From: Rich Elliott <elliotttr@kvfr.org>
Sent: Thursday, December 11, 2014 4:29 PM
To: Kaycee Hathaway
Cc: Joe Seemiller; John Sinclair
Subject: RE: Notice of Application : CU-14-00005 McDonald

Was able to access. The following is our input on the proposed CUP:

Drawing file: CU-14-00005 McDonald / CU-14-00005 McDonald Site Plan.pdf

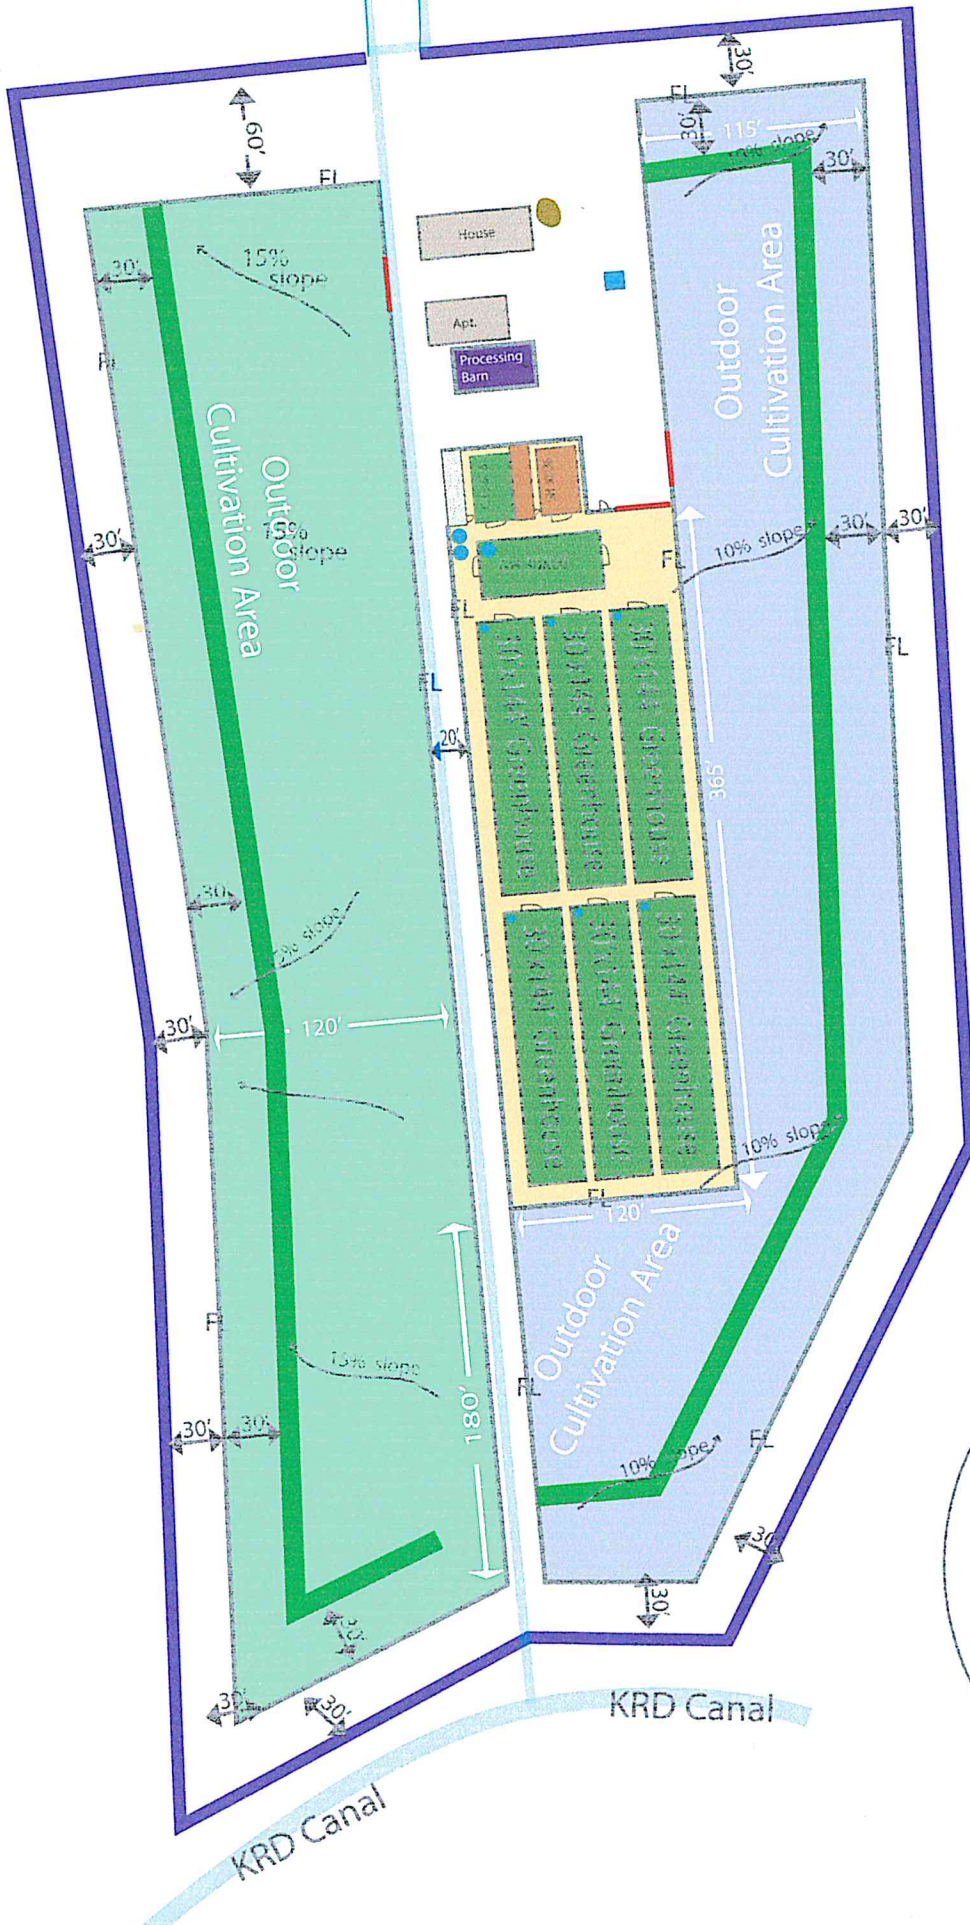
- Access to all improvements must meet current edition of the IFC – Appendix D.
- Keyed access to all secure facilities – Knox box.
- Information related to any special support systems – (CO2, chemical processing etc...)
- Addressing clearly visible from both directions of travel and all buildings clearly labeled.
